OXFORDSHIRE COUNTY COUNCIL'S RESPONSE TO CONSULTATION ON THE FOLLOWING DEVELOPMENT PROPOSAL

Application no: 15/00920/F

Proposal: To provide a new temporary access road off Middleton Stoney Road to access the building compound, car parking and materials storage serving KM4 Parcel

Location: KM4 South West Bicester Development Site Wetherby Road Bicester

DRAWING TITLE: TEMPORARY CONSTRUCTION ACCESS OFF MIDDLETON STONEY ROAD

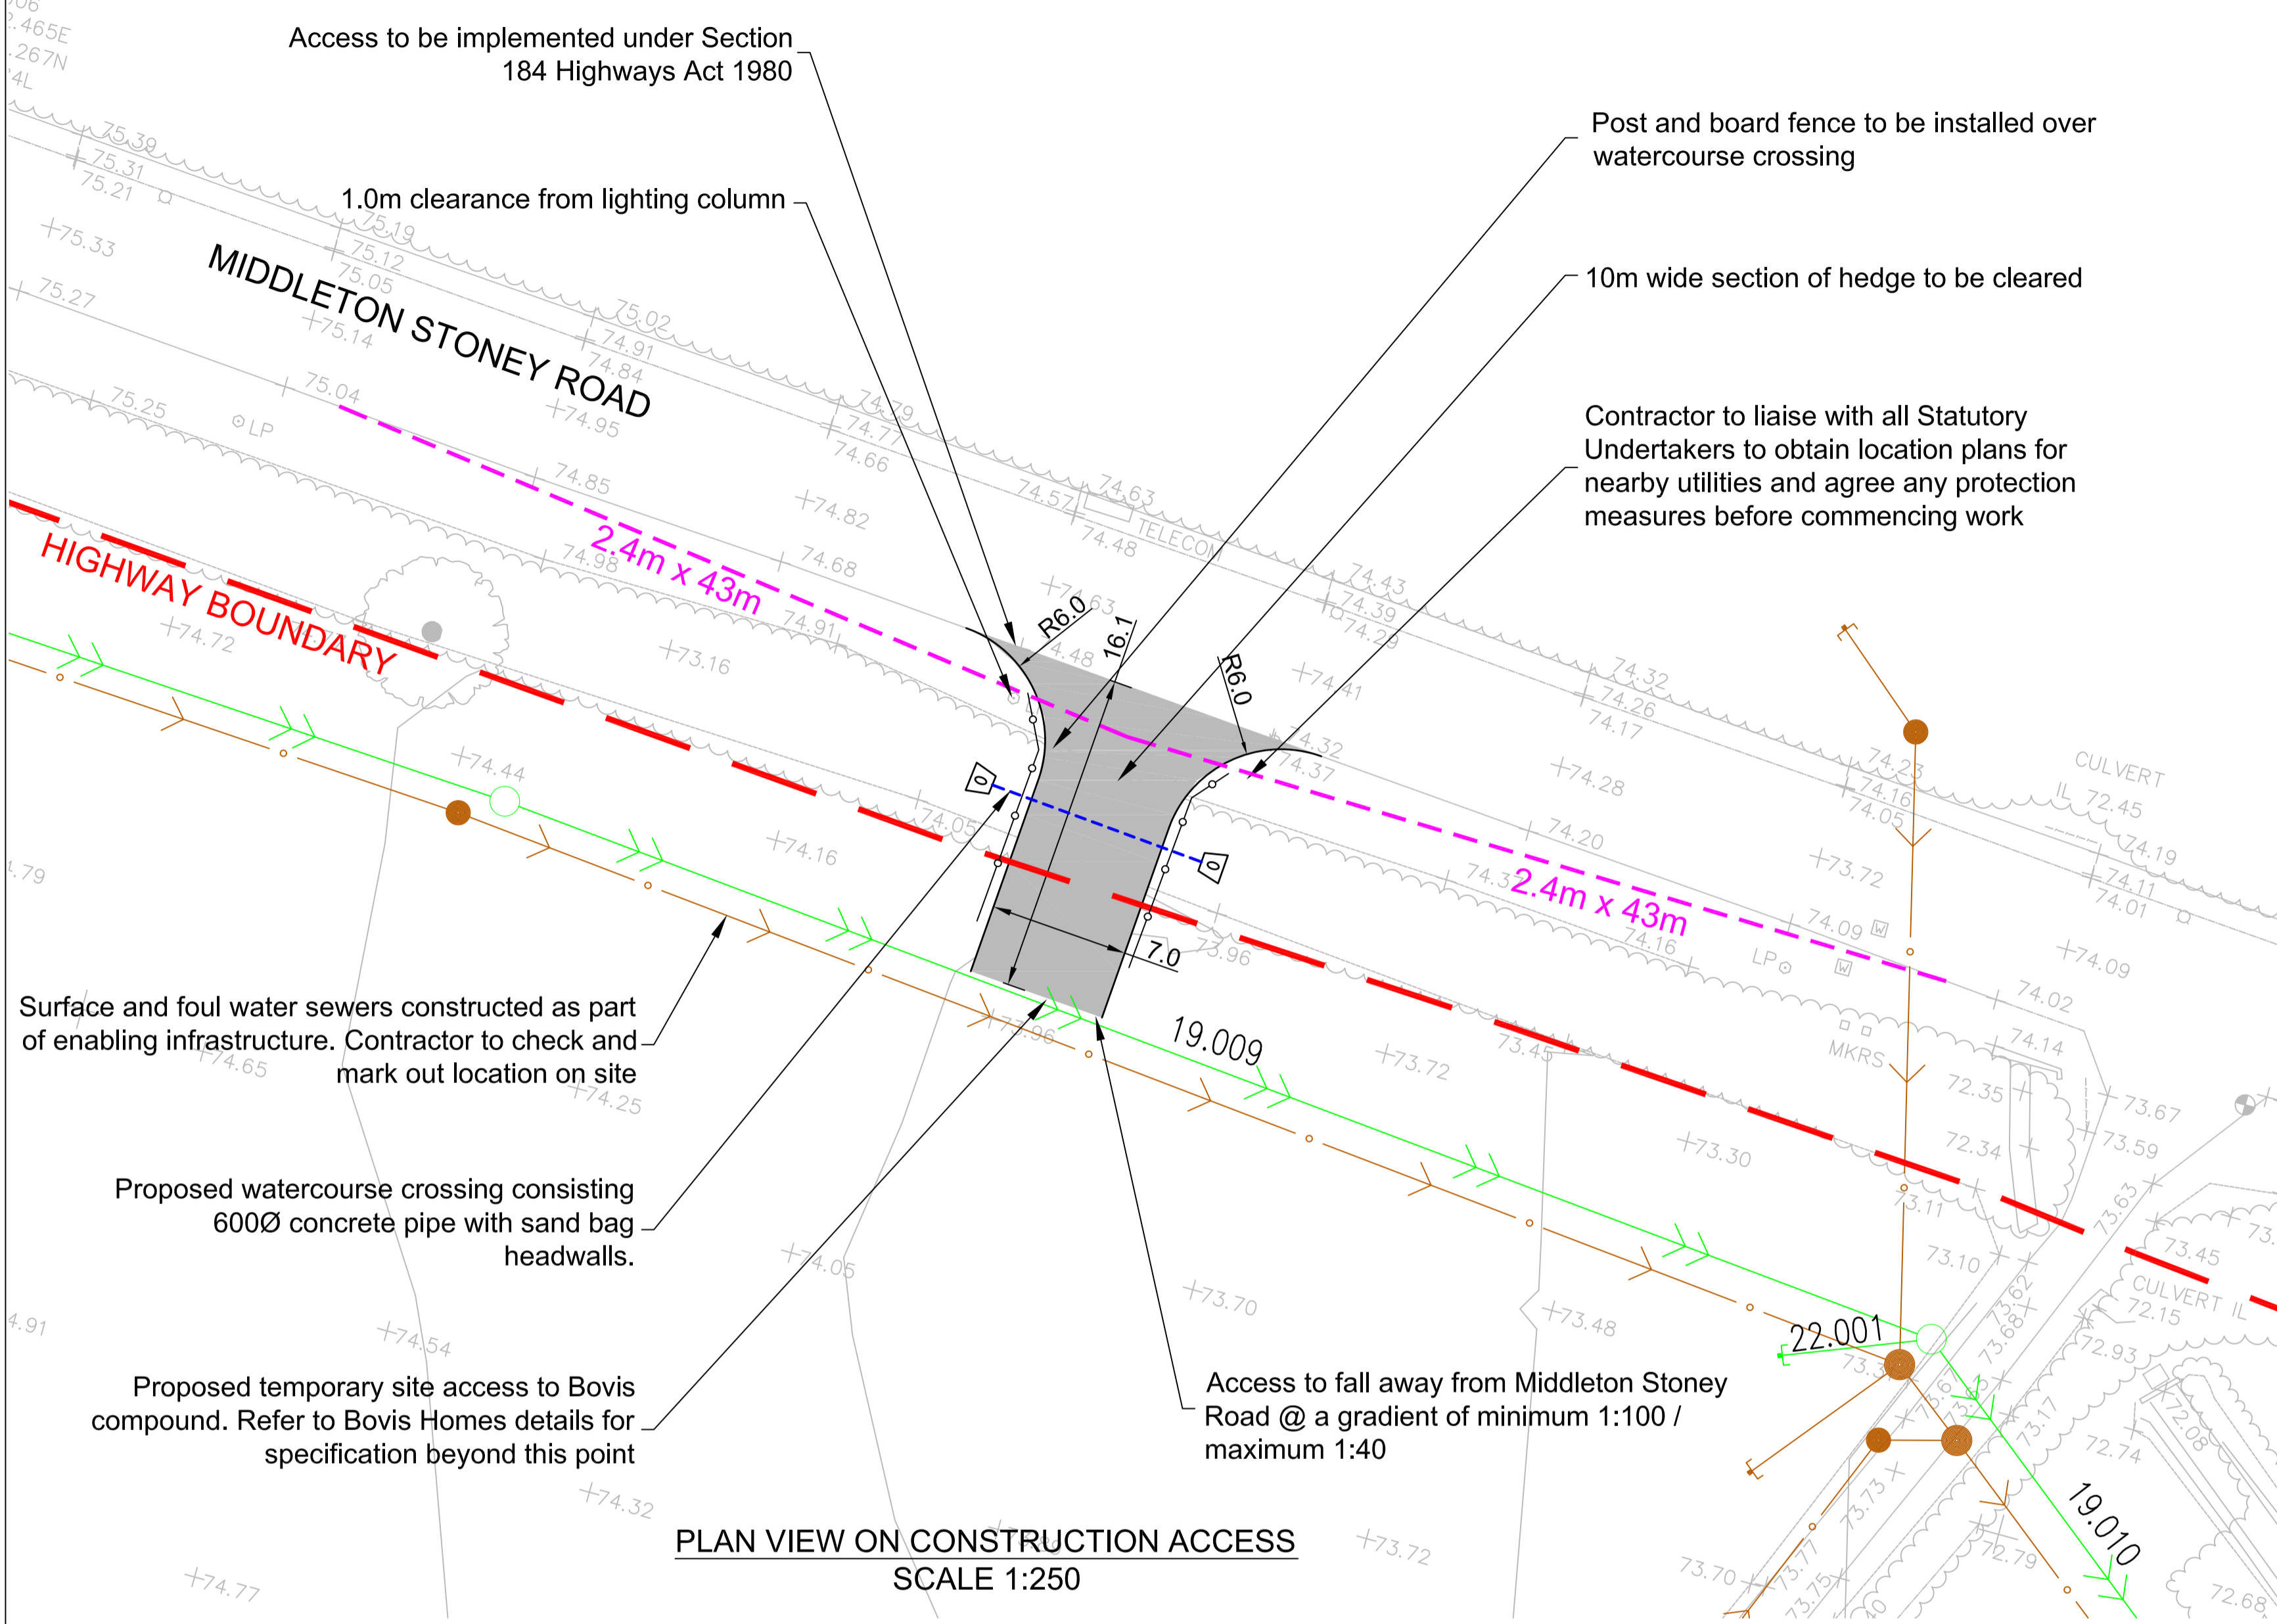
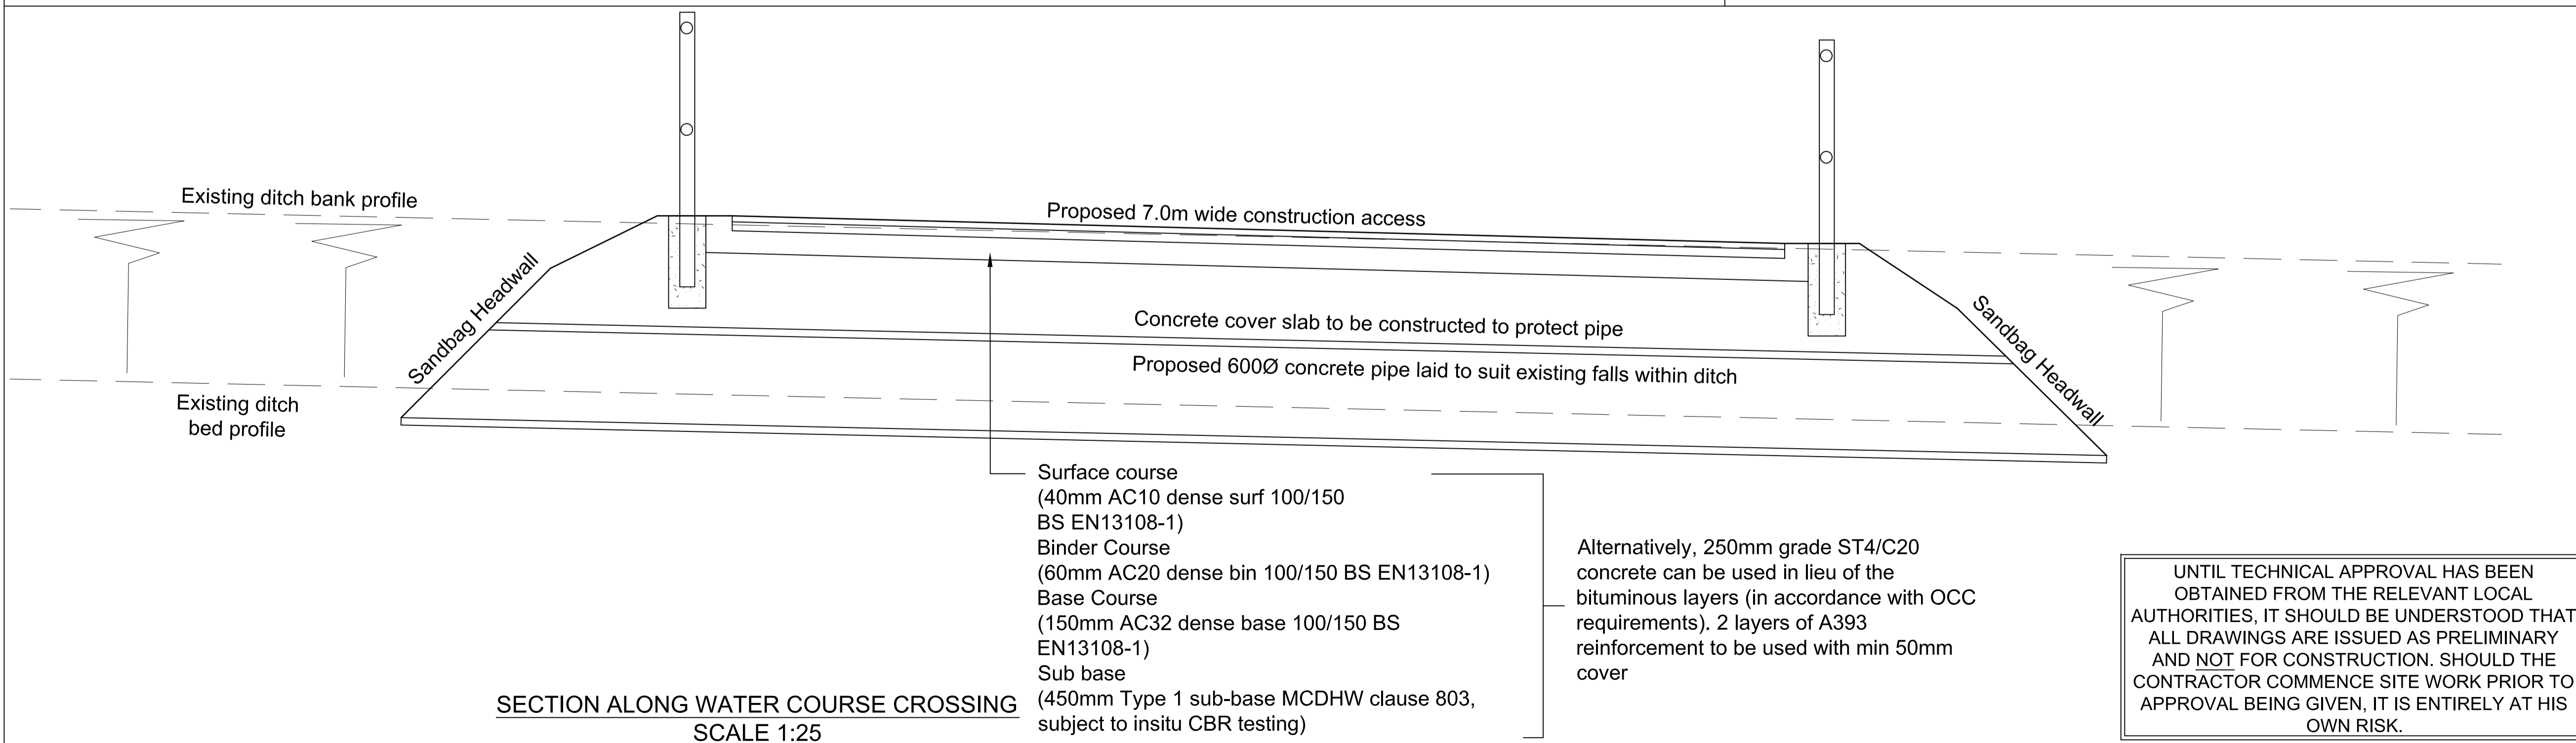
Prior to the commencement of the development hereby approved, full details of the means of access between the land and the highway, including, position, layout, construction, drainage and vision splays shall be submitted to and approved in writing by the Local Planning Authority. Thereafter, the means of access shall be constructed and retained in accordance with the approved details. *Reason - In the interests of highway safety and to comply with Government guidance contained within the National Planning Policy Framework*

It is considered that the proposed temporary access for KM4 on Middleton Stoney Road will operate safely. A temporary access (just to the east) for an earlier phase of the Kingsmere development operated for between 18 months and 2 years before the Shakespeare Drive main access roundabout was opened. There were no reported injury accidents at or in the vicinity of that temporary access. Since that access was closed, a 30mph speed limit has been introduced on Middleton Stoney Road. Bearing that in mind and the details that have been submitted this new temporary access is considered to be acceptable. This is despite the fact that a westbound bus stop is located immediately to the east of the proposed access. Buses only currently run twice an hour during the daytime Monday to Saturday. This is not sufficiently frequent for it to pose a real risk to safety, particularly given the predicted low volume of traffic that will be using the construction access.

However, in order to ensure that the access works as safely as possible, the county council believes that a routing agreement for HGVs should be in place to minimise any possible negative side effects of the junction and the HGVs using it on road safety and traffic congestion. This could ensure that HGVs only turn right in or left out of the access and that onward journeys from the site are on the most suitable parts of the local road network – considered to be Vendee Drive. This will be agreed before works start.
